Andrew Beattie - BERRY RIDING CLUB

From: "Jan Golding" <janhowie@bigpond.com>
To: <plan_comment@nsw.gov.au>
Date: 16/12/2012 7:29 AM
Subject: BERRY RIDING CLUB

The Issues Associated with the Design of the Proposed Relocation of the Berry Equestrian Centre

This submission concerns the impact of the proposed Foxground and Berry Bypass on the Berry Equestrian Centre which is located in North Street Berry.

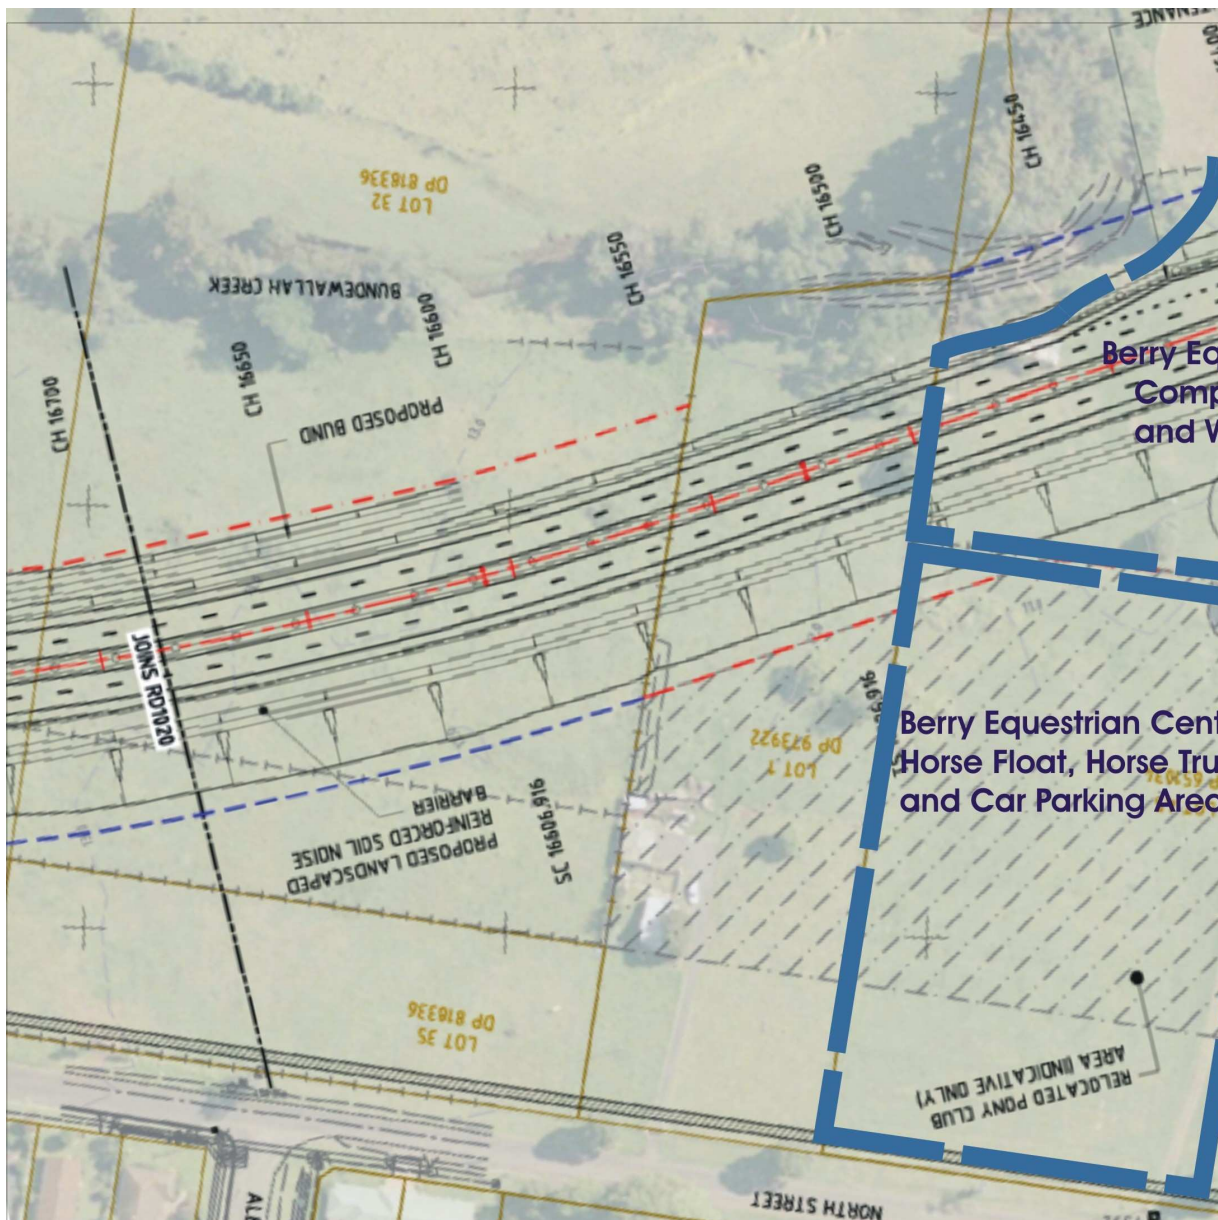
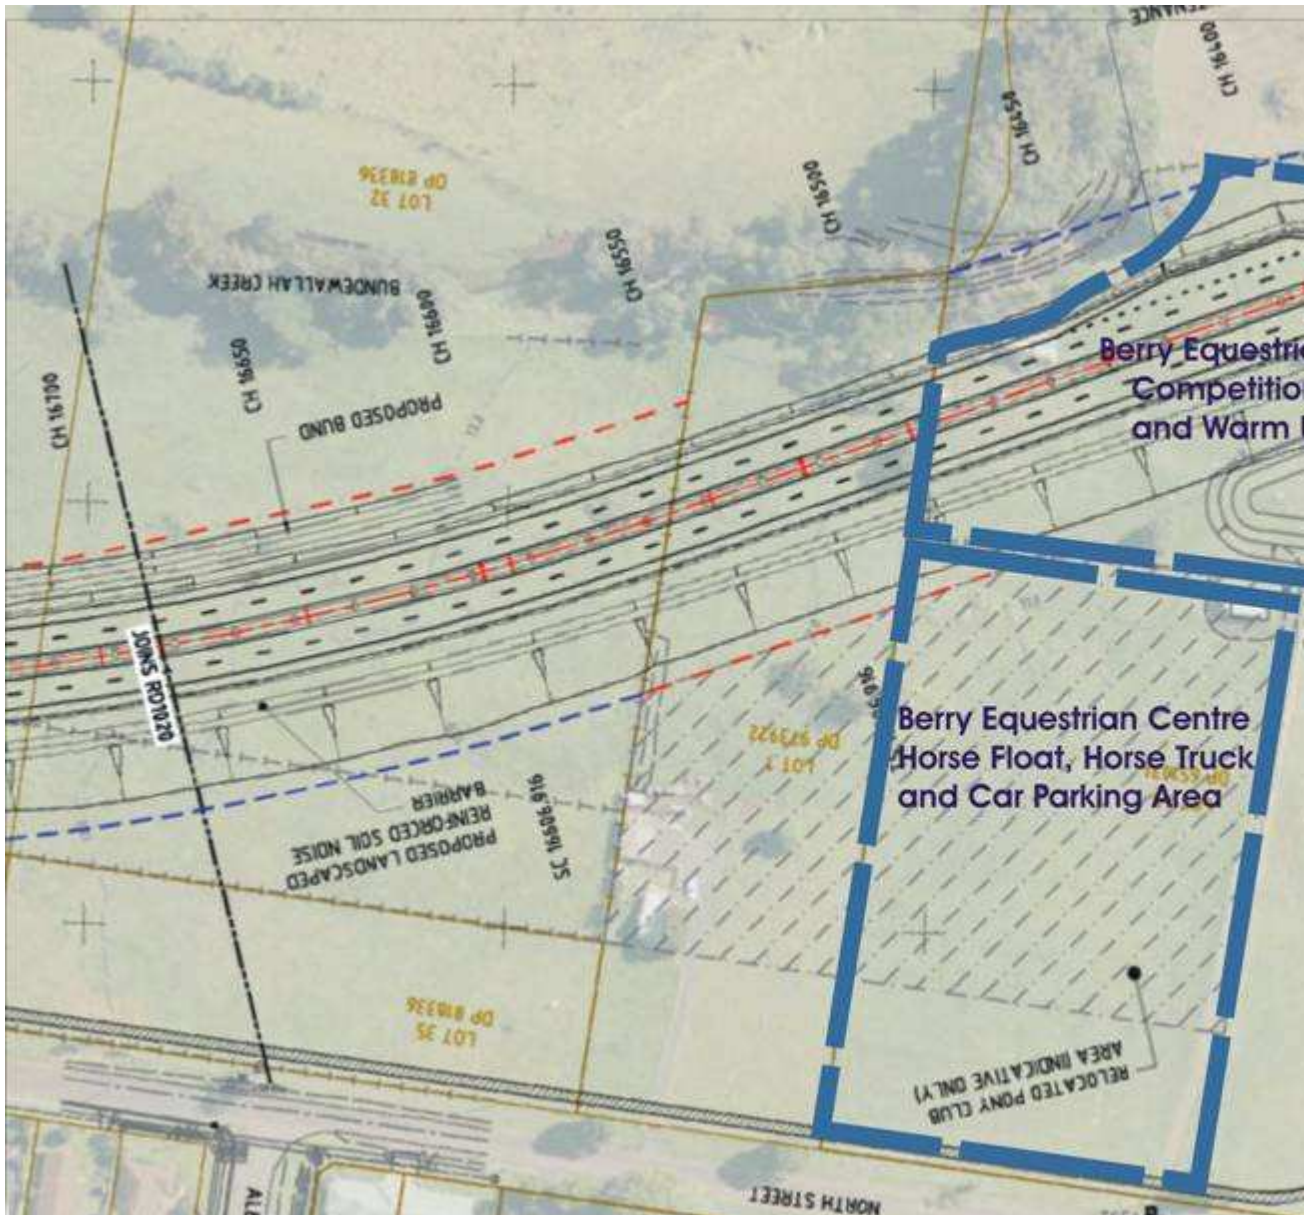
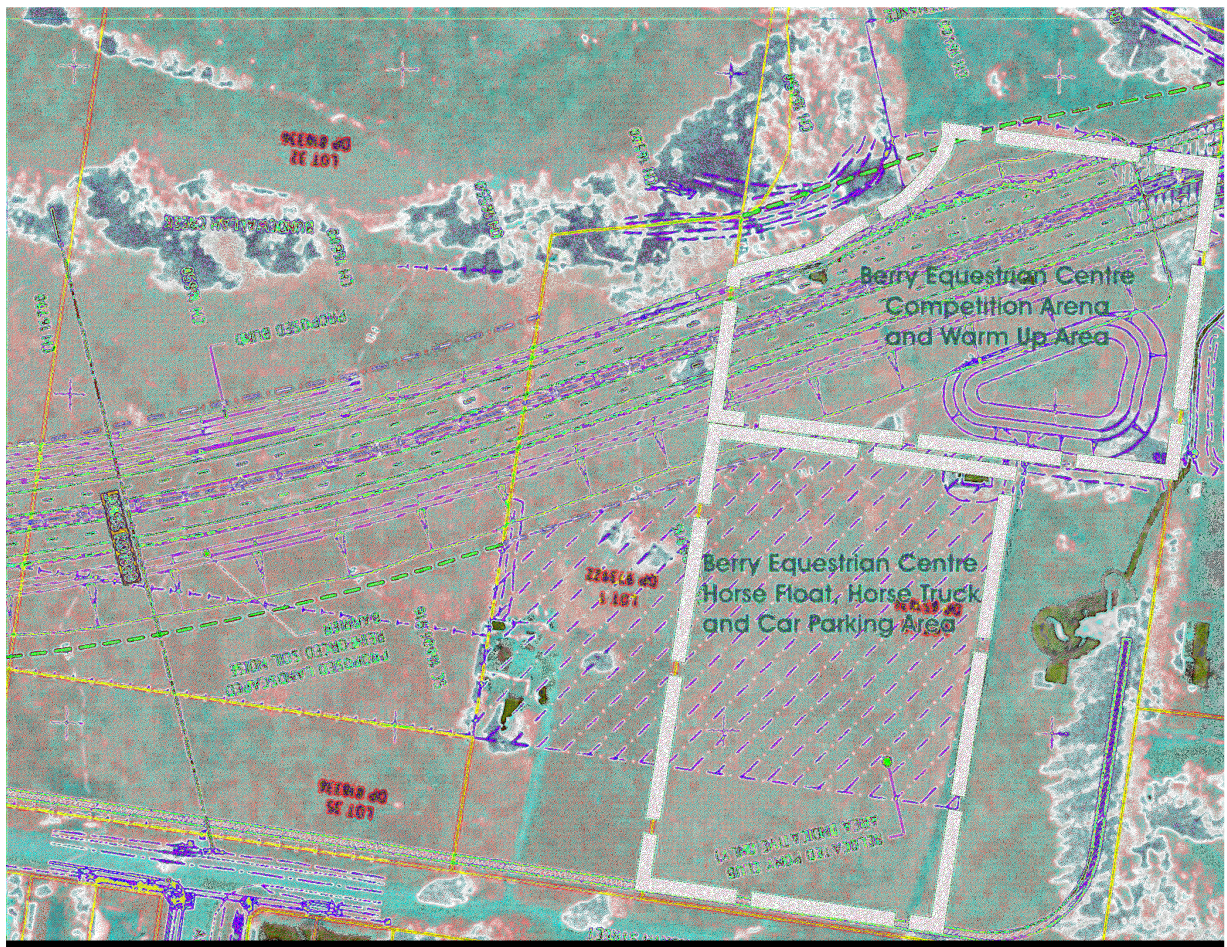
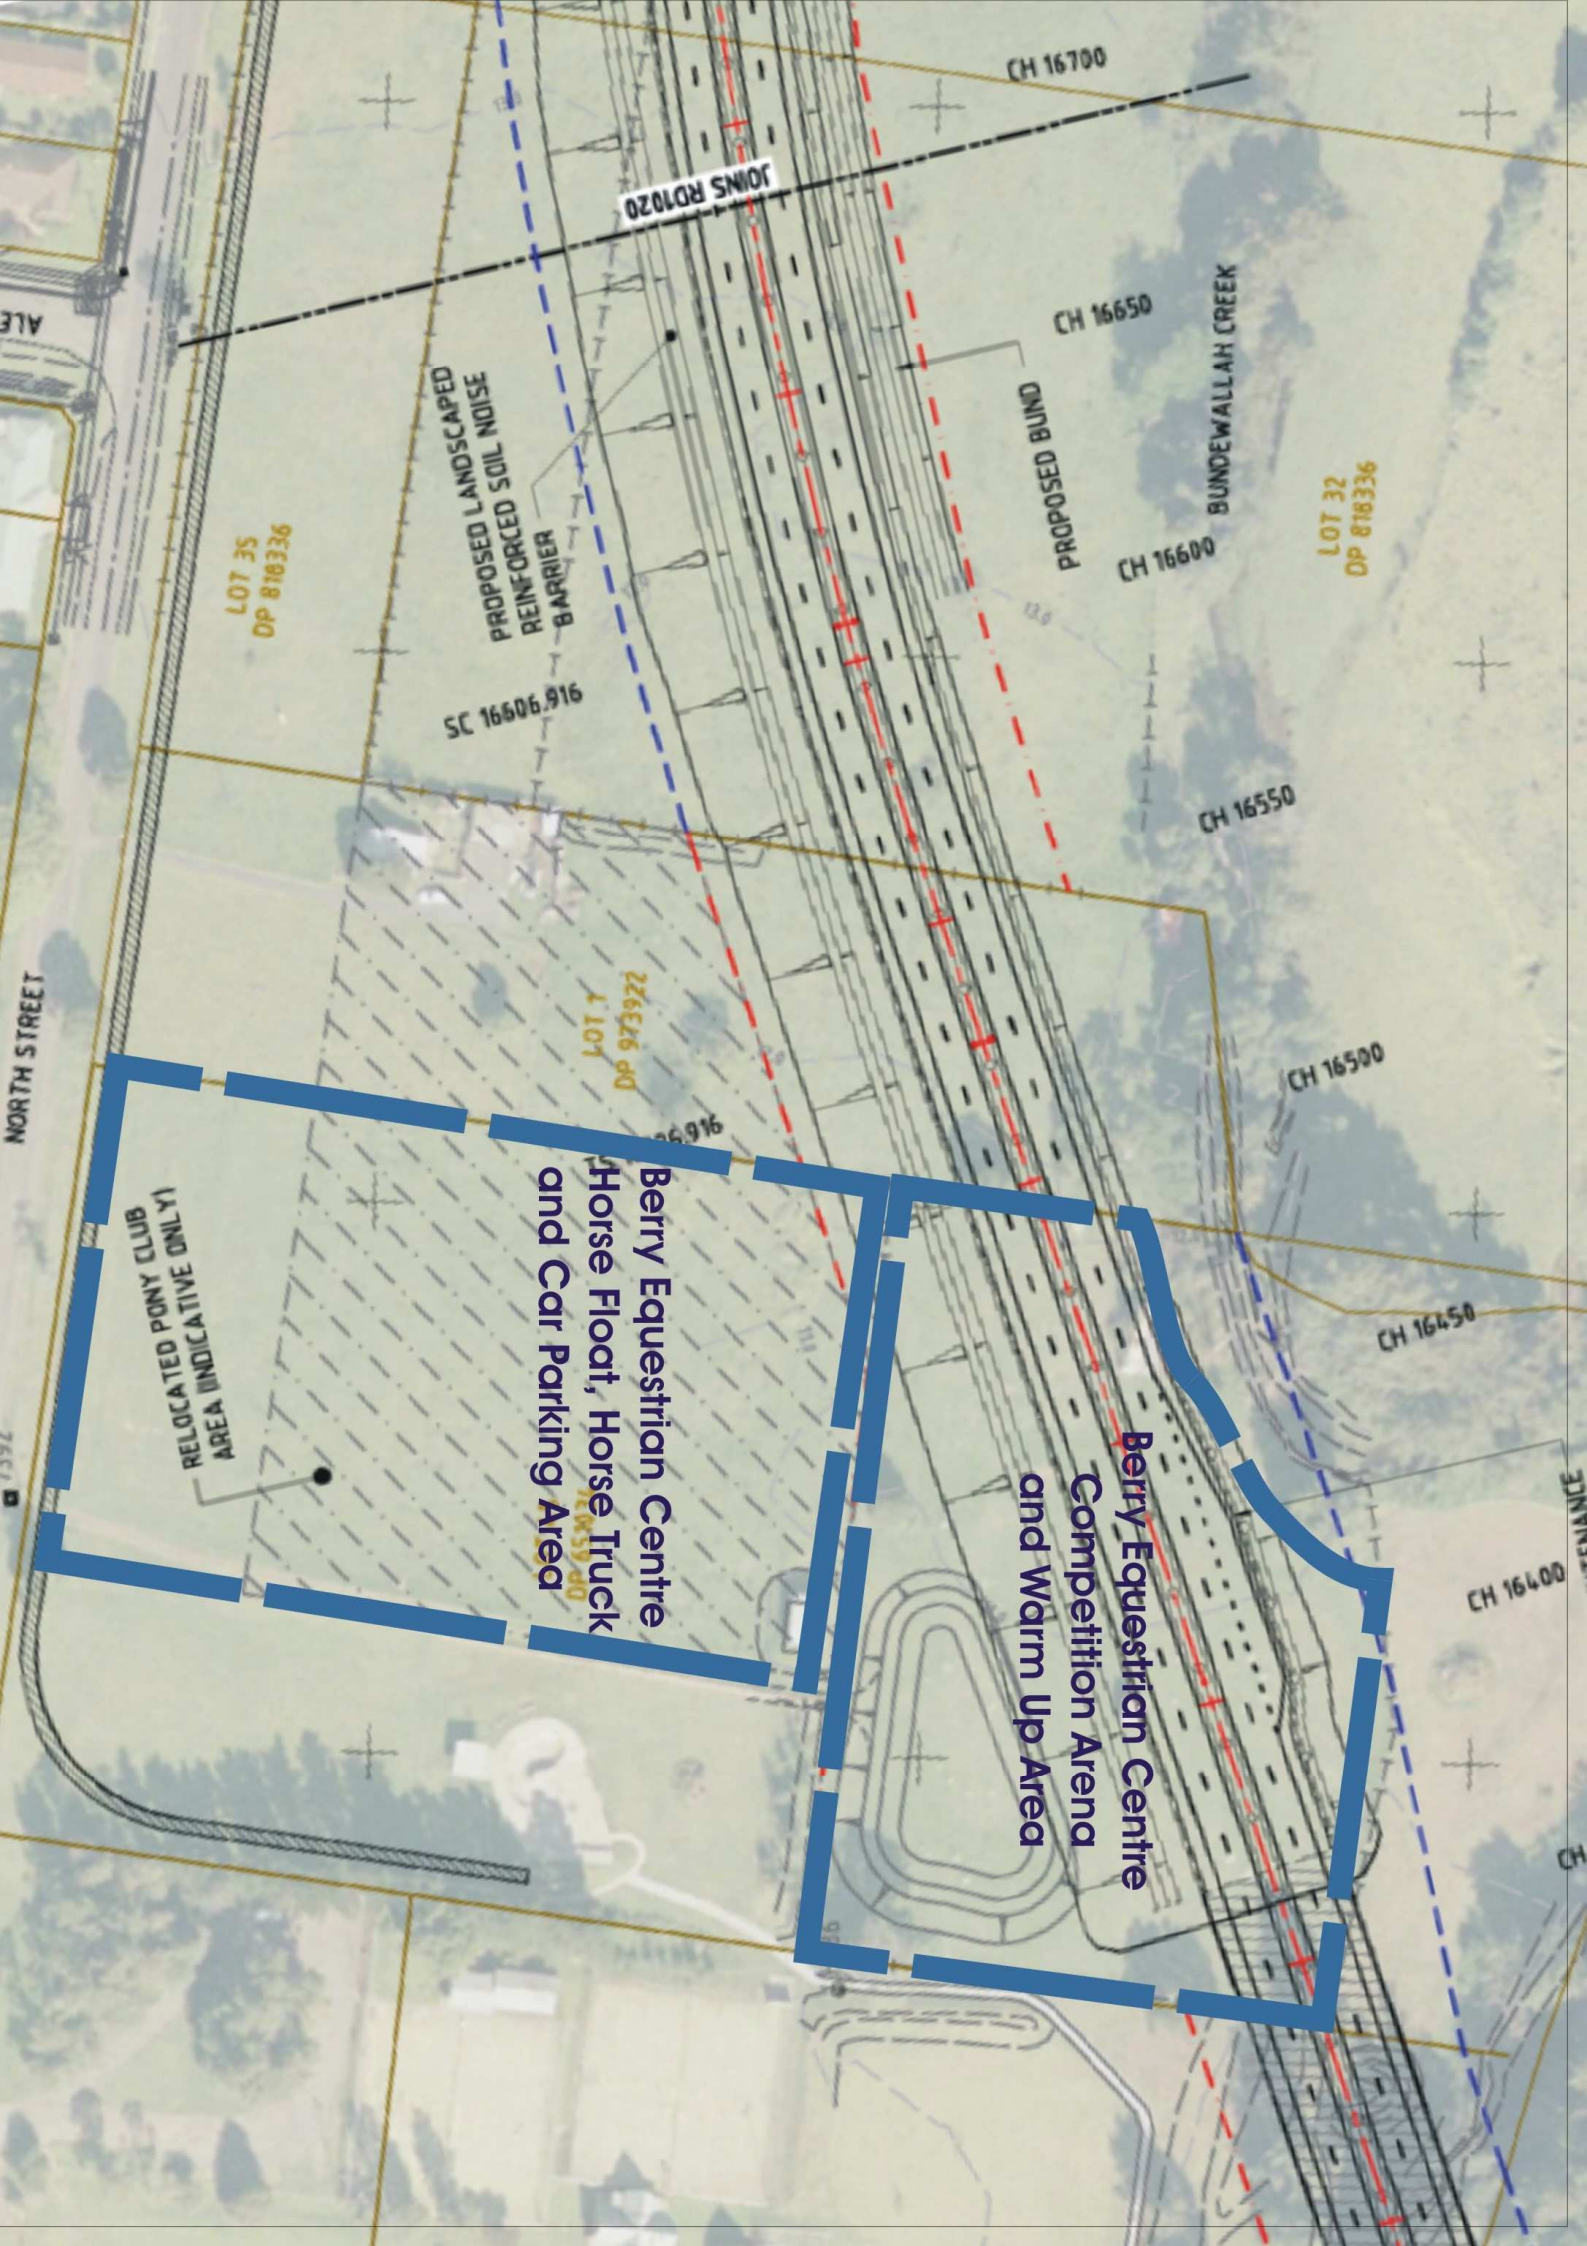
The design and loss of land of the proposed relocation of the Berry Equestrian Centre will have a significant impact on the ability to conduct events. It will impact riders, participants and spectators in the following ways.

1. The competition grounds are required to be rectangular /square in shape of a minimum size of 140 metres x 140 metres with a level, well drained, good riding surface in order to cater for at least 4 dressage arenas or 2 showjumping arenas.

2. The parking area is required to be of a minimum area equivalent to 90 metres x 160 metres and allow for easy entry, maneuverability, parking and exit of horse floats and trucks. Each parking space is equivalent to an absolute minimum of 4 normal vehicle spaces due to the need for unloading/loading and tie up areas for horses.

3. There is concern for the safety of horses, riders and the general public due to the near location of the proposed riding area to the 4 lane expressway, the skateway, the public cycleway/walkway and North Street. There will be anticipated significantly increased noise and visibility of cars and trucks travelling at 100km/hour on the expressway with horses competing nearby, often with young, very inexperienced riders.

4. Access to the grounds is likely to be across a public shared cycleway/pathway. The safety of children on skateboards, bicycles etc are at risk as horse trucks and floats cross the pathway. Horse floats and trucks also require an indented driveway of at least 15 metres to allow vehicles to park off the roadway whilst gates to the grounds are opened.
